4 Harefield Road
Middleton on Sea
Bognor Regis
PO22 6EB

M/7/26/HH

I am writing on behalf of the Committee of the Harefield Estate Association to strongly object to this application.

Proposed South Elevation

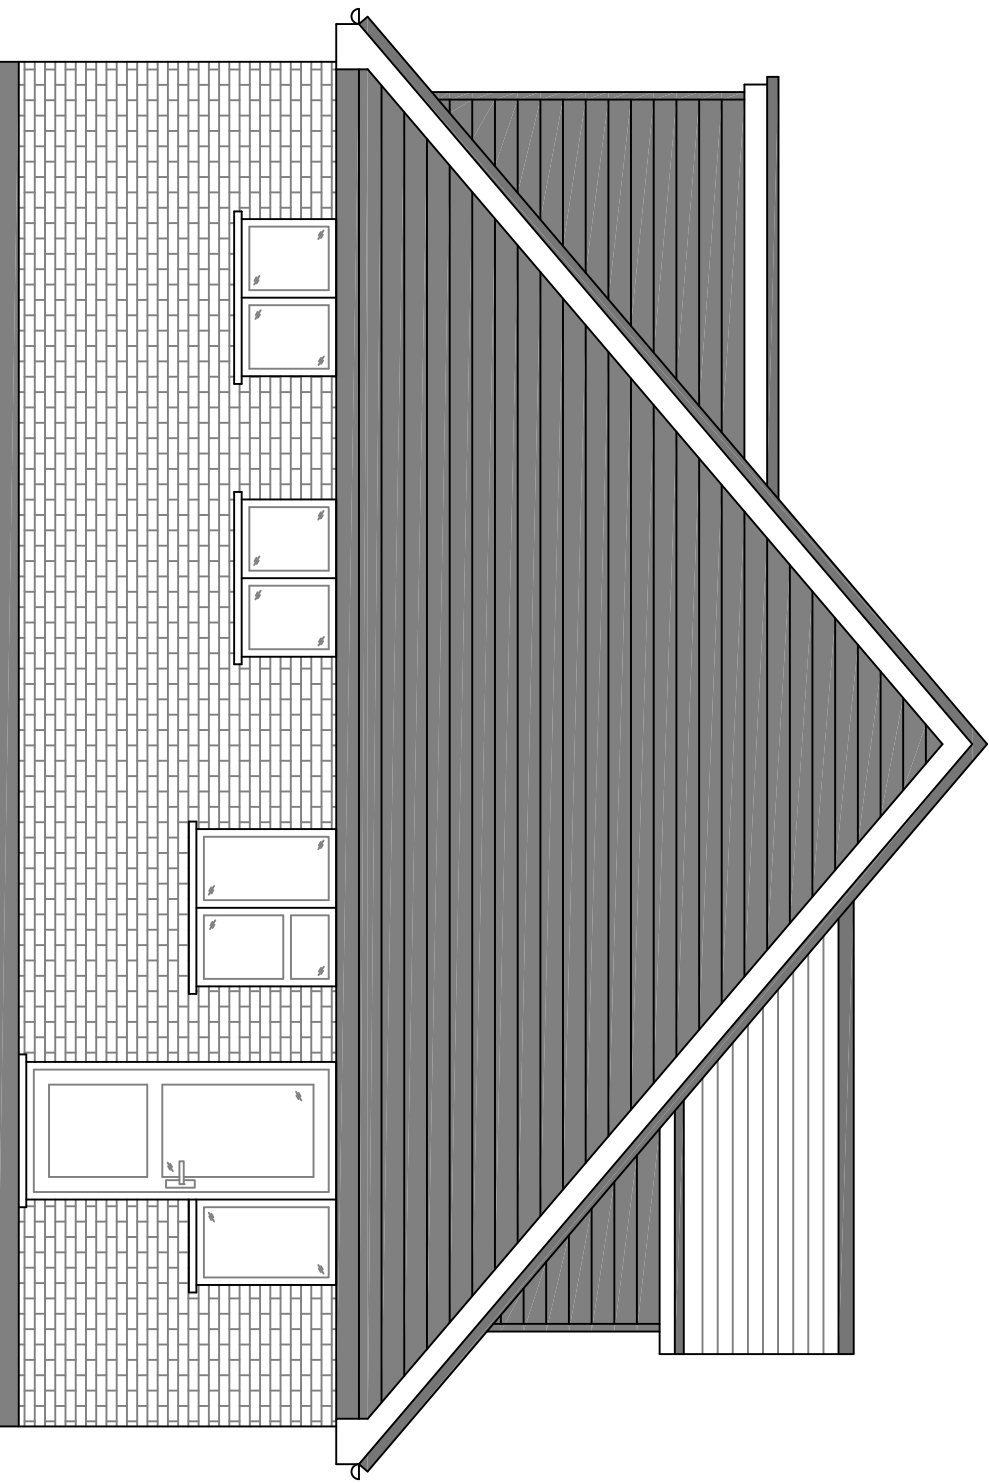
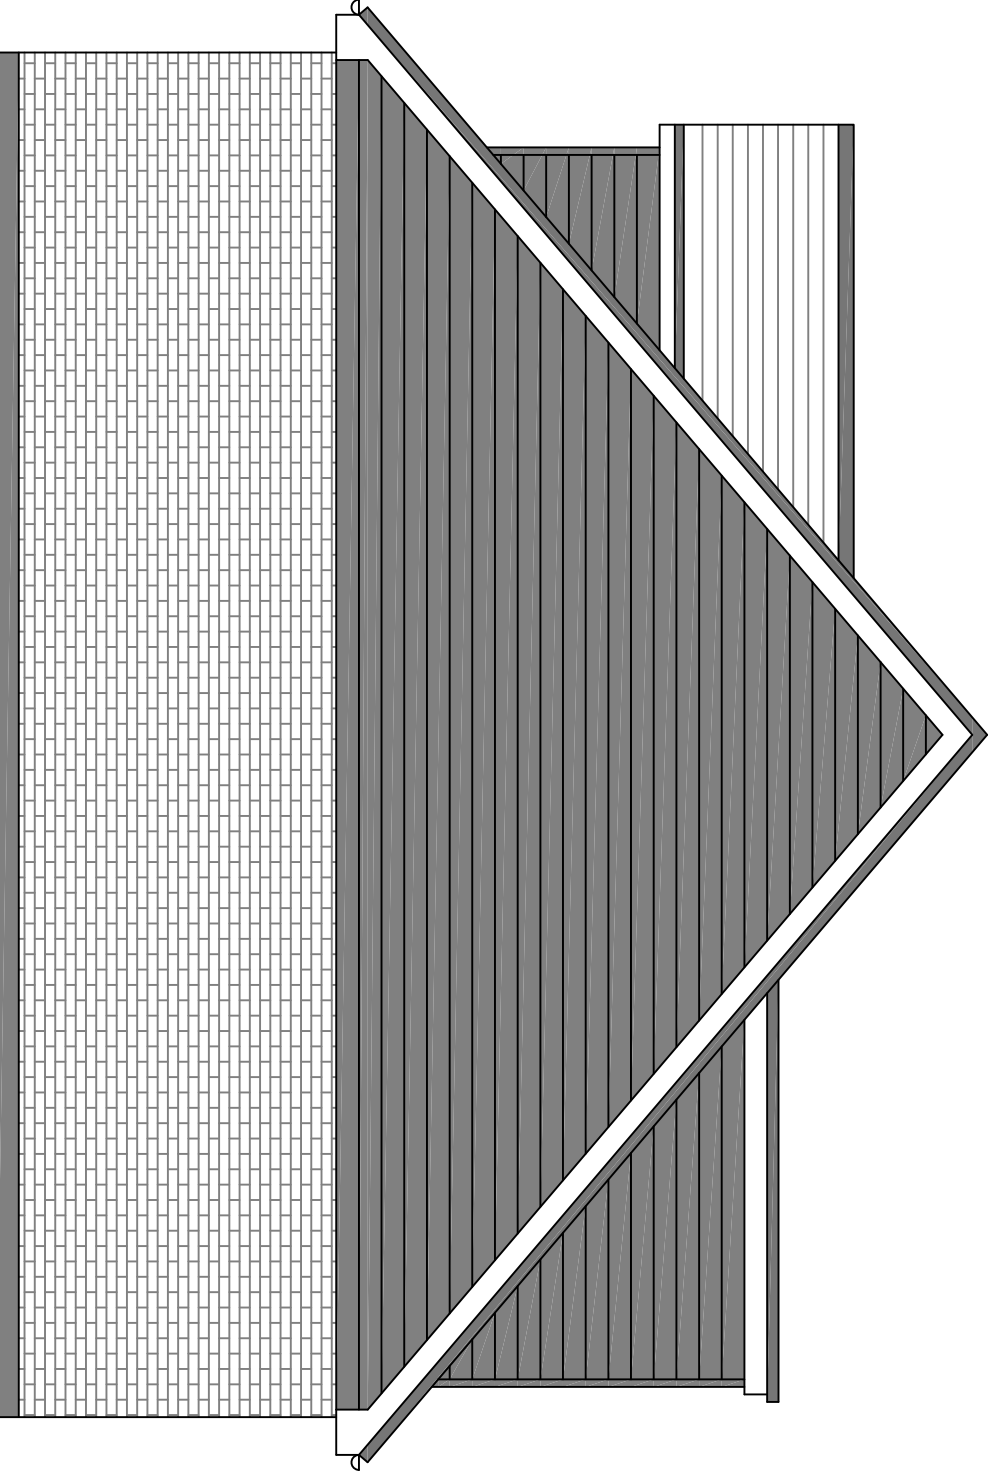
However, the plans propose an increase in the roof area, yet provide no evidence in support of the statement that the drainage is sufficient. No monitoring of ground water data has been supplied in support of this application. Nor has there been any infiltration testing as far as we are aware.

Finally the proposed design is in conflict with both the Arun design guide, and with the Middleton

“Alterations to the roof profile should not detract from the character and appearance of the dwelling or wider area in any case. This can be achieved through smaller scale dormer windows with pitched roofs which, when used in combination, tend to be more successful than single, large flat-roofed box-shaped dormers.”

Proposed Side and First Floor Extension Site Location Planning
Date August 2024
Scale 1:200 1:1250

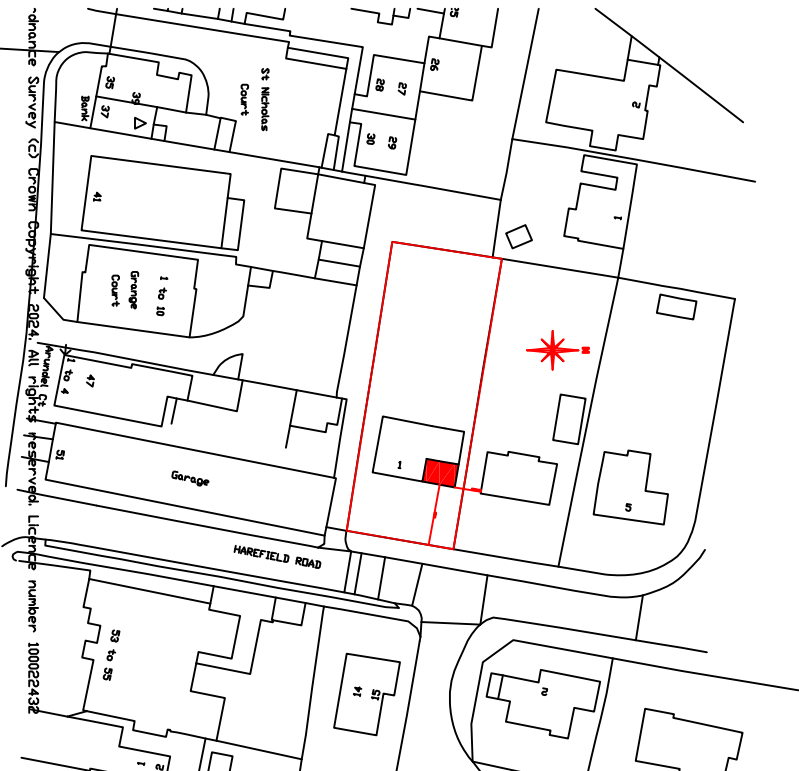
1) The plan submitted with the application shows the original boundaries of 1 Harefield Road and agrees with the layout filed with the land registry. However the size of the plot has been substantially reduced by the expansion of the yard area to the south and west (Land registry Title number WSX90392). As such the proposed extension is an over-development for a plot of this size. While we understand - as explained in the Officers Recommendation Report for application M/12/25/HH -

The site has already been subdivided in practice without obtaining permission. Surely either permission to subdivide the site should be obtained, or the site returned to its original boundaries prior to granting permission to extend the building.
